From: Simon Davis
Sent: 25 January 2019 14:29
To: [REDACTED]
Cc: Daniel Vick <Daniel.Vick@arun.gov.uk>
Subject: FW: Y/92/18/DOC- Further Drainage Supporting Info

From: Laura Gibbons
Sent: 25 January 2019 11:33
To: Simon Davis <Simon.Davis@arun.gov.uk>
Subject: RE: Y/92/18/DOC- Further Drainage Supporting Info

Eastern Bank of Reservoir

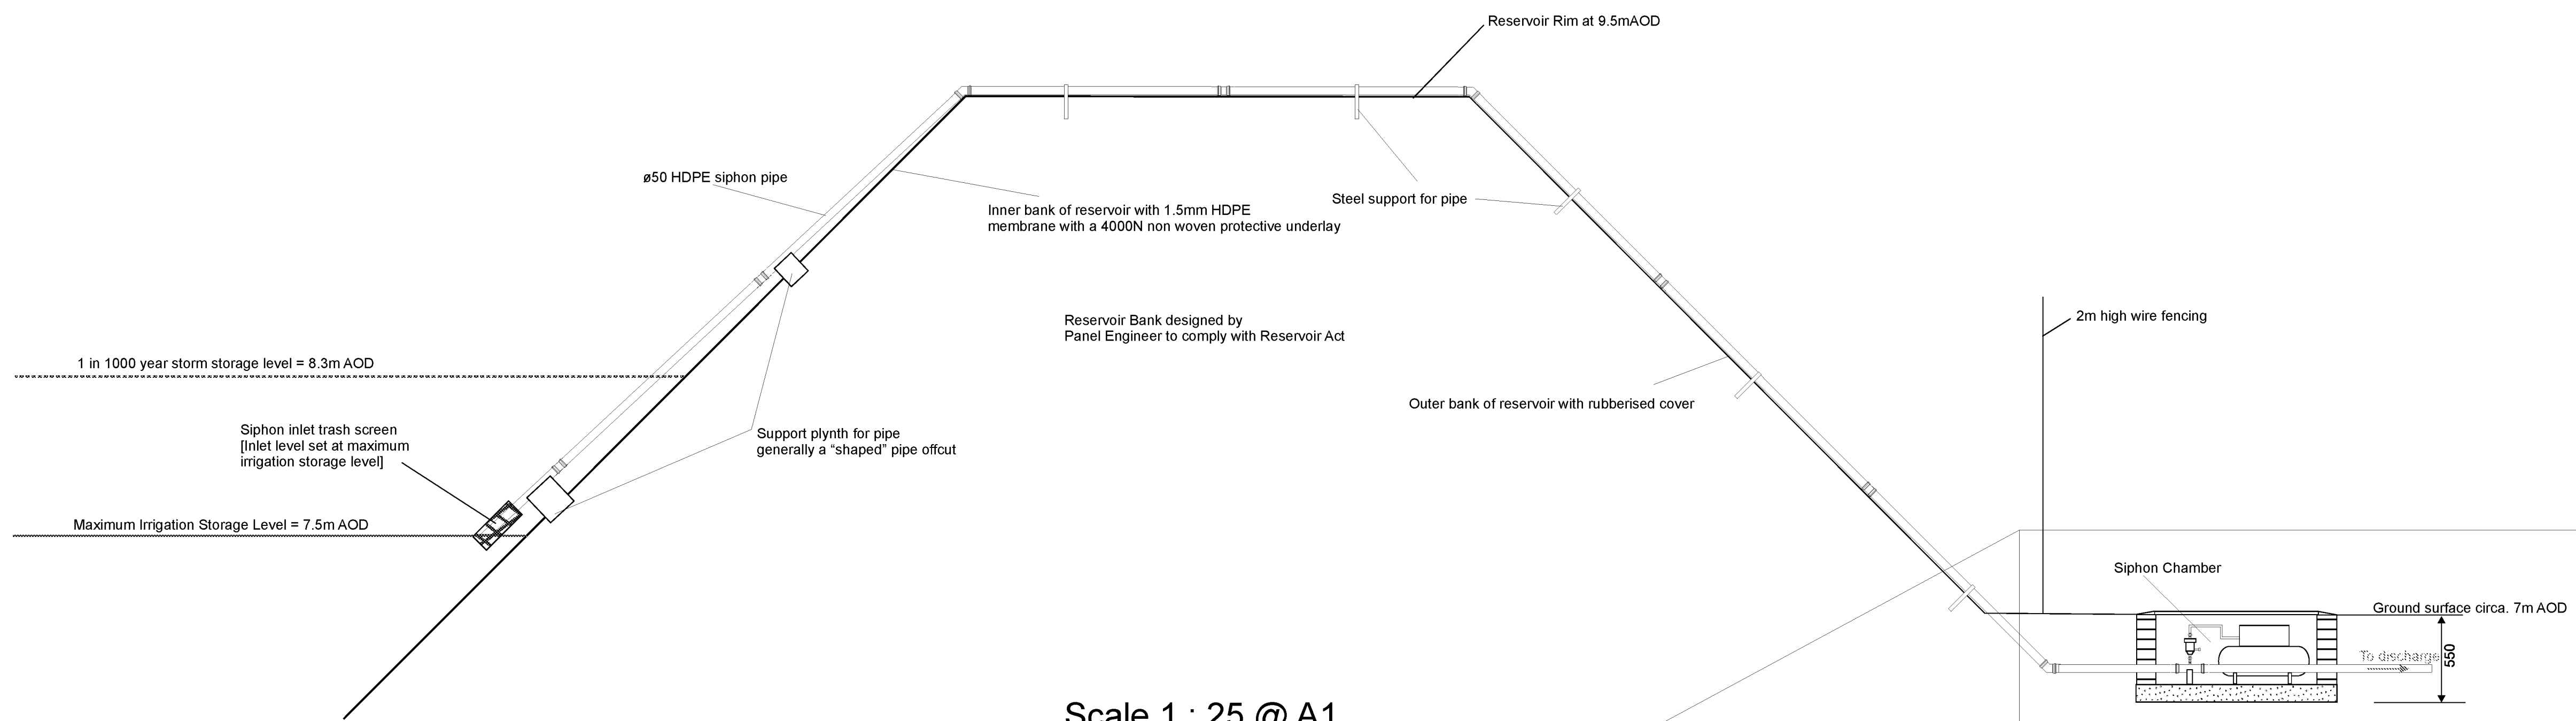
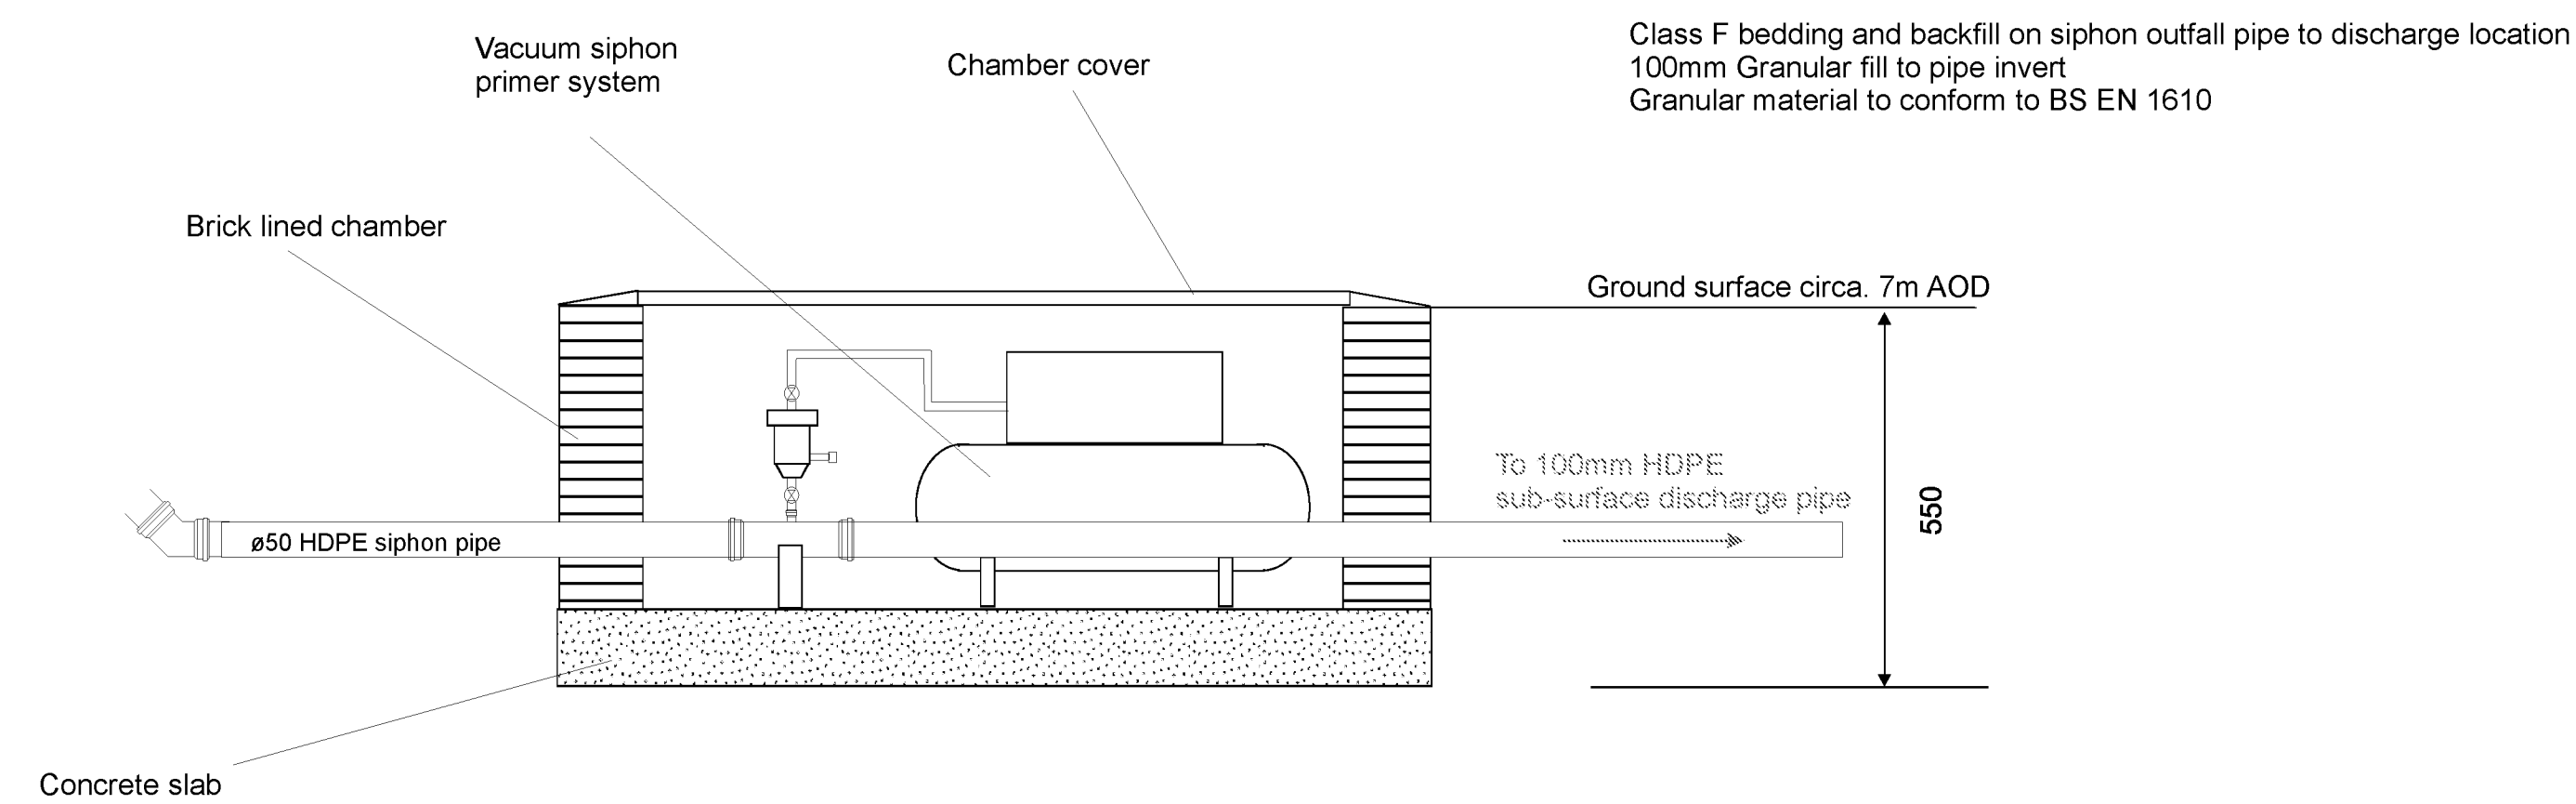
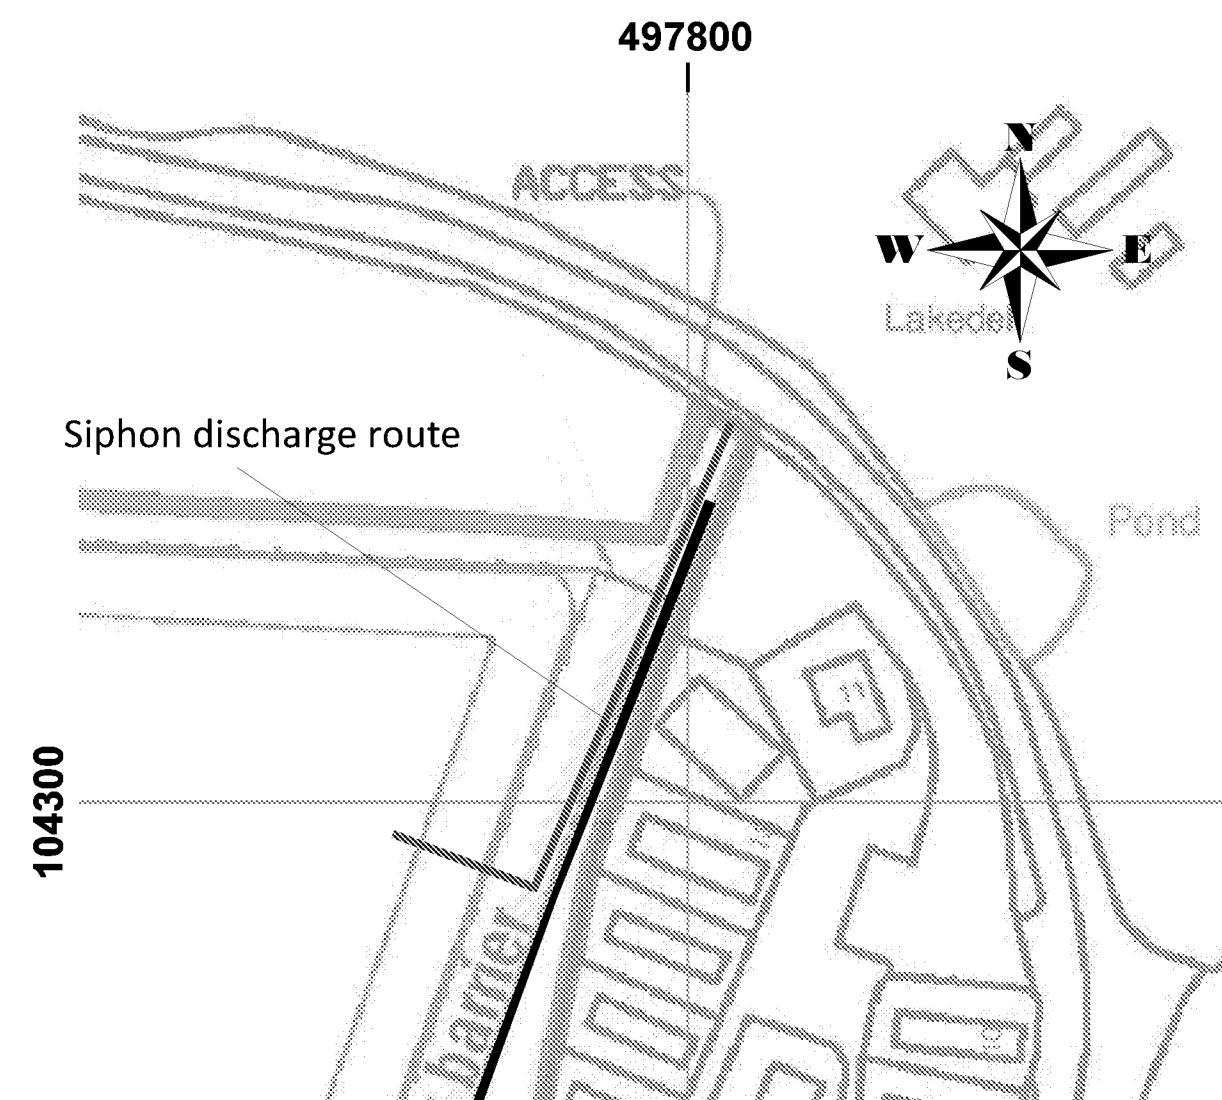
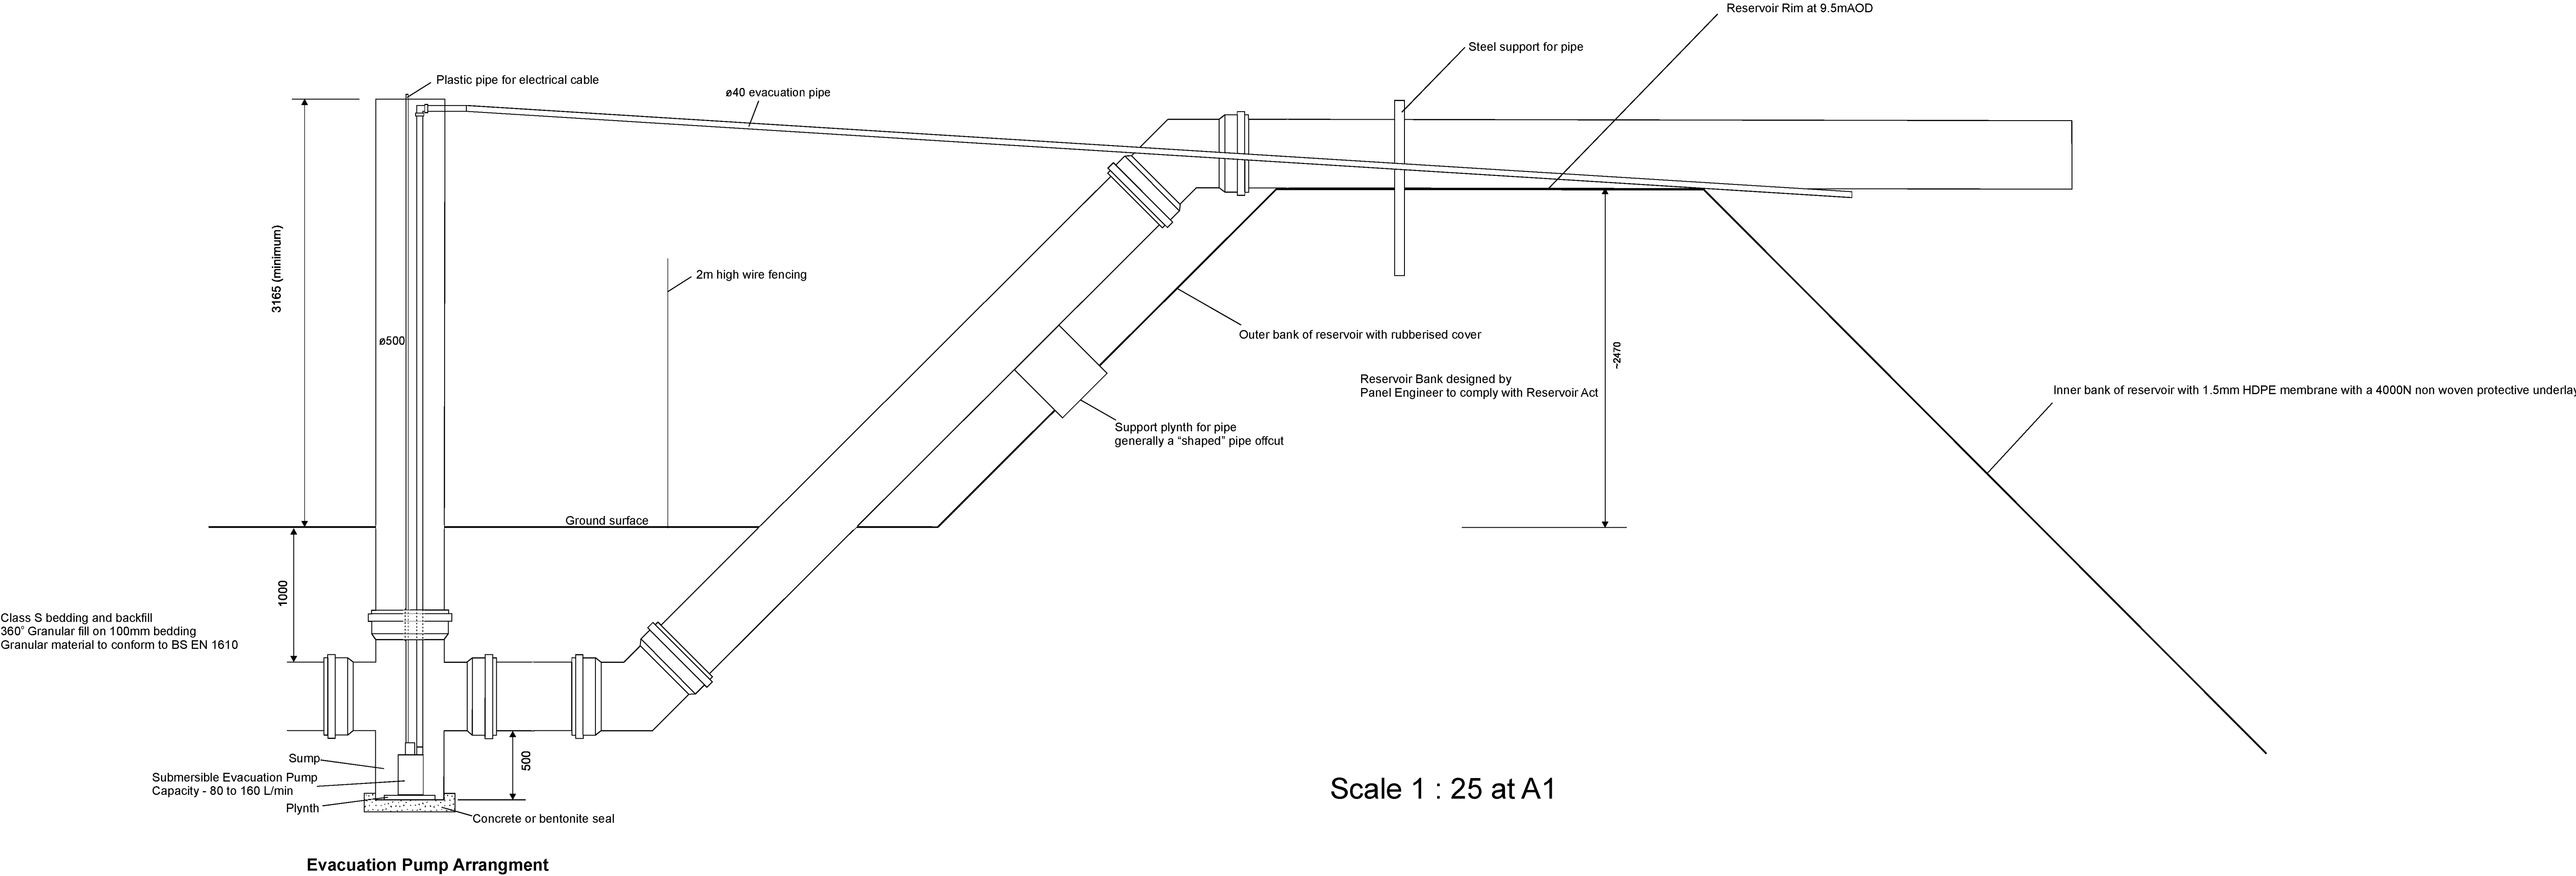
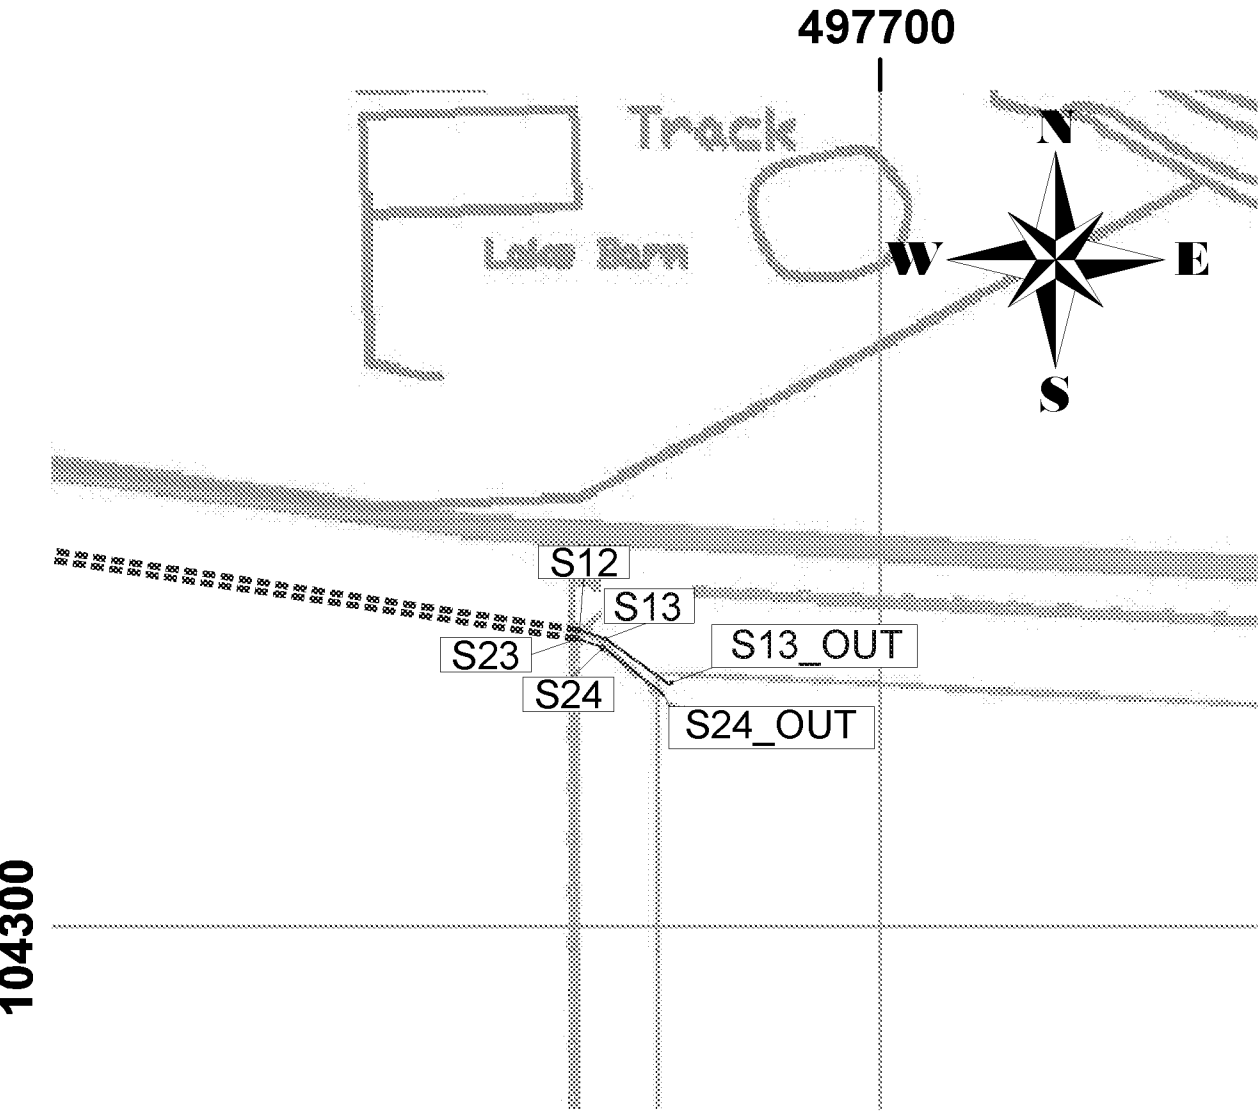
7. Full details of the attenuation basin will therefore need to be provided.
8. No dimensions have been provided on the attenuation basin and siphon drawings. This needs to be detailed.

L-Bloc® / 1.2m / Reinforced

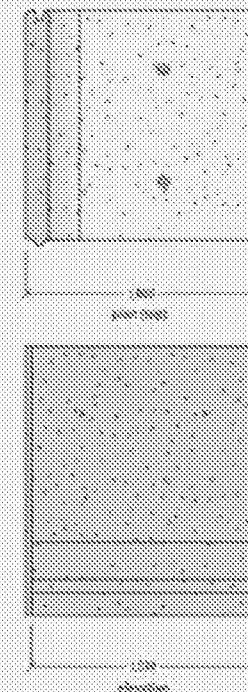
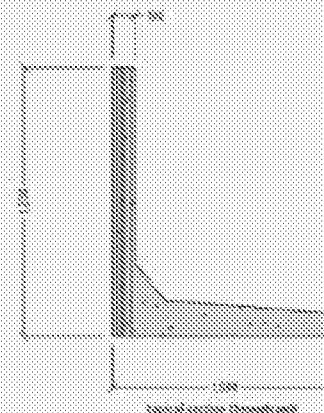
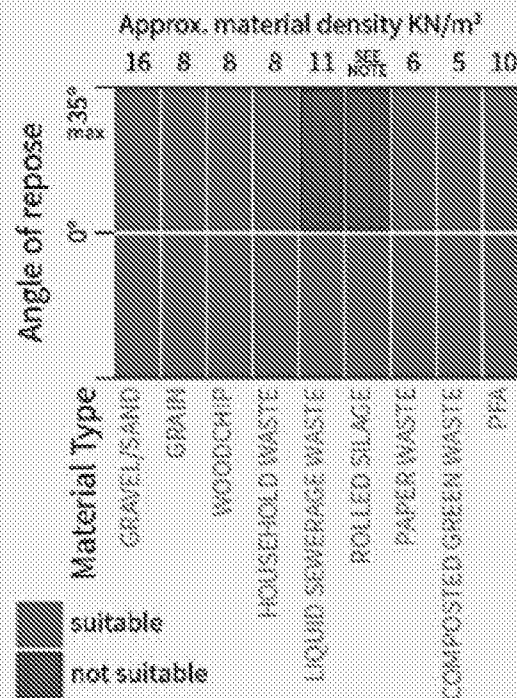
5. Insufficient details of the flood barrier have been provided. Please provide site specific drawings which include the concrete slab base and connectivity to the barrier.
